From:
To: [DCAdmin](#)
Cc: [Nick Hirst](#)
Subject: Planning Application 2020/93954 - Spin Dryer Effect
Date: 23 January 2023 12:25:16
Attachments: [spin dryer effect.pdf](#)

Please find attached a personal comment concerning the revised housing development off Lingards Road.

Project	Housing at Lingards Road, Slaithwaite	William Best RIBA
Client	S B Homes Ltd	The Chapel House
Drawing	SITE SECTIONS H, J, K	22 Pole Gate
Scale	1:200	Scammonden
		West Yorkshire
		HD33FW
Dwg No	2019 572 55	Tel 01484 845896
	Rev C

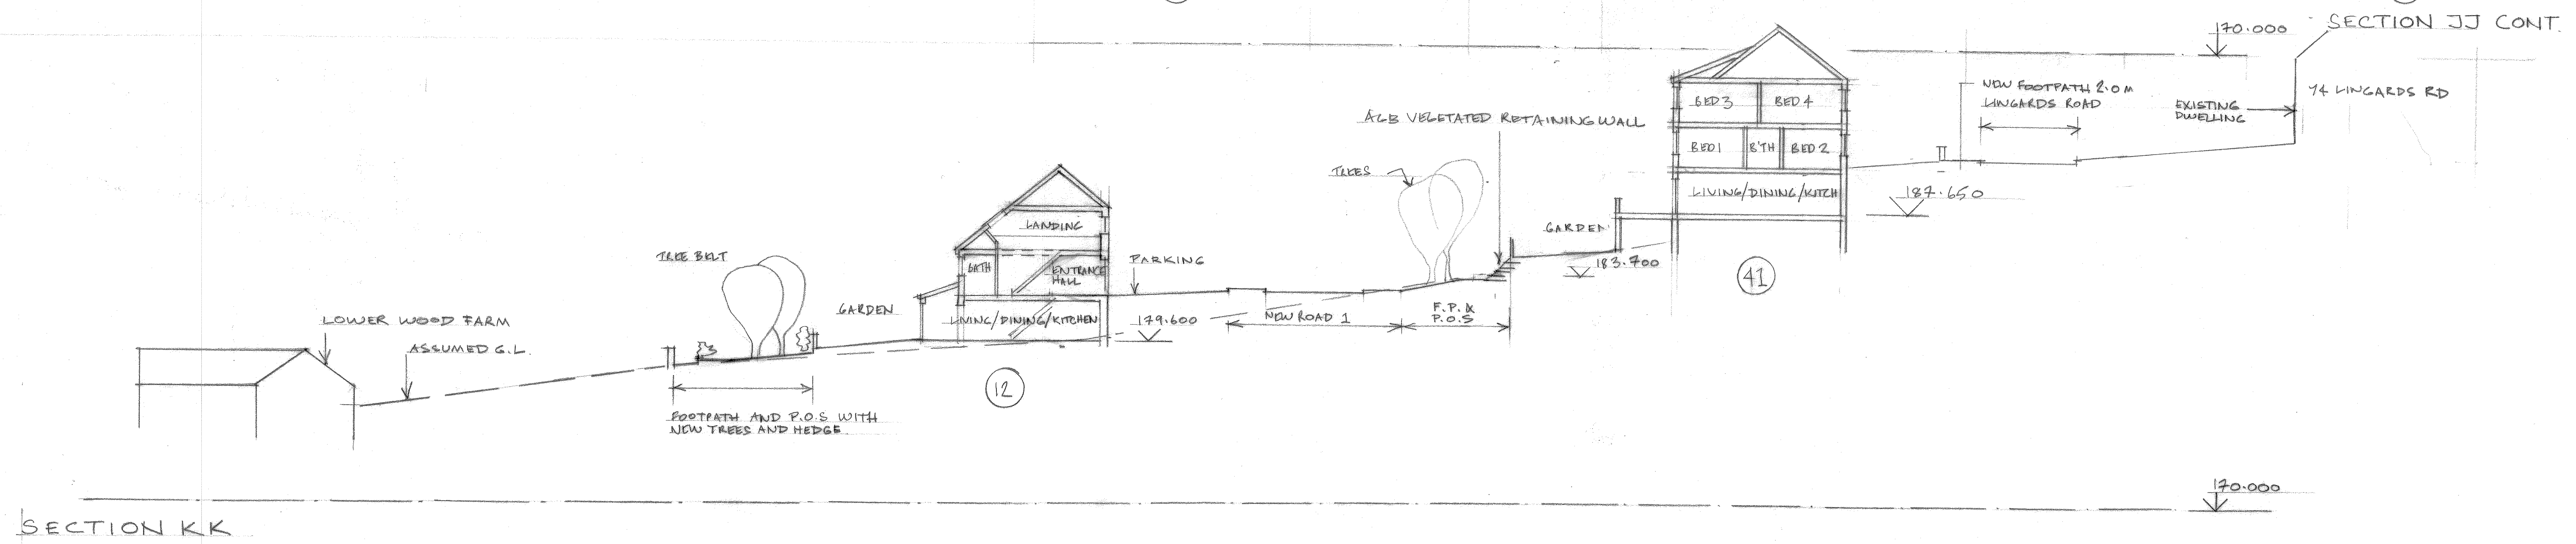
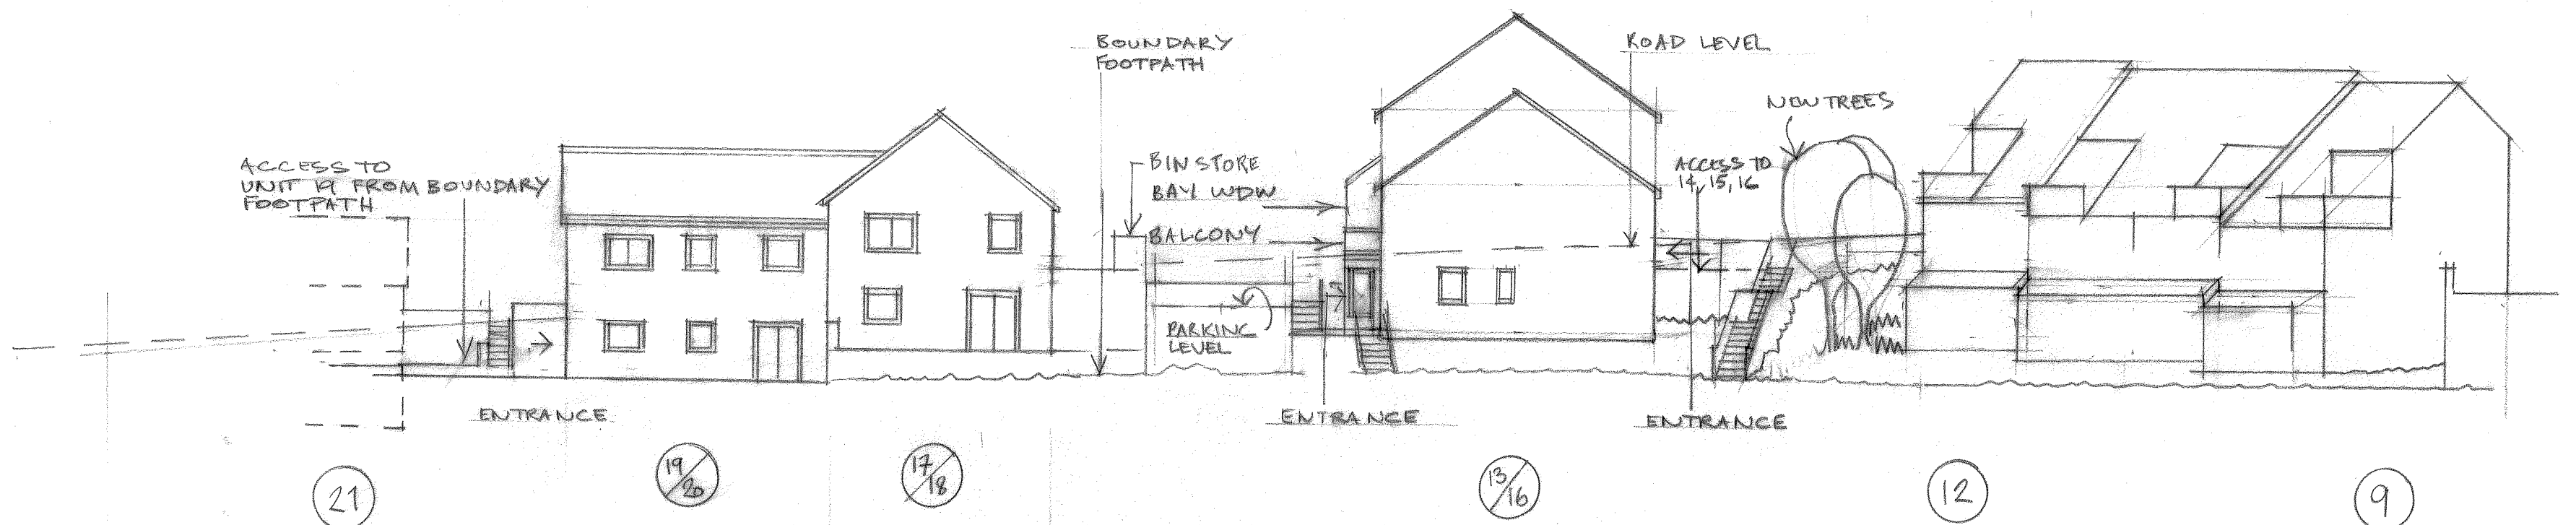
What this application seems to propose, for quite a number, is to terrace the site, in order to unnaturally elevate the dwellings way above the existing ground levels.

Then, whereas some developments might use a retaining wall to support it, this application is going to need something bigger.

This application proposes to use a retaining system, which is designed to withstand the huge volume of infill material required to achieve the desired elevation, which I have no doubt it would.

This elevation seems primarily intended to allow, proposed dwellings, direct access off Lingards Road.
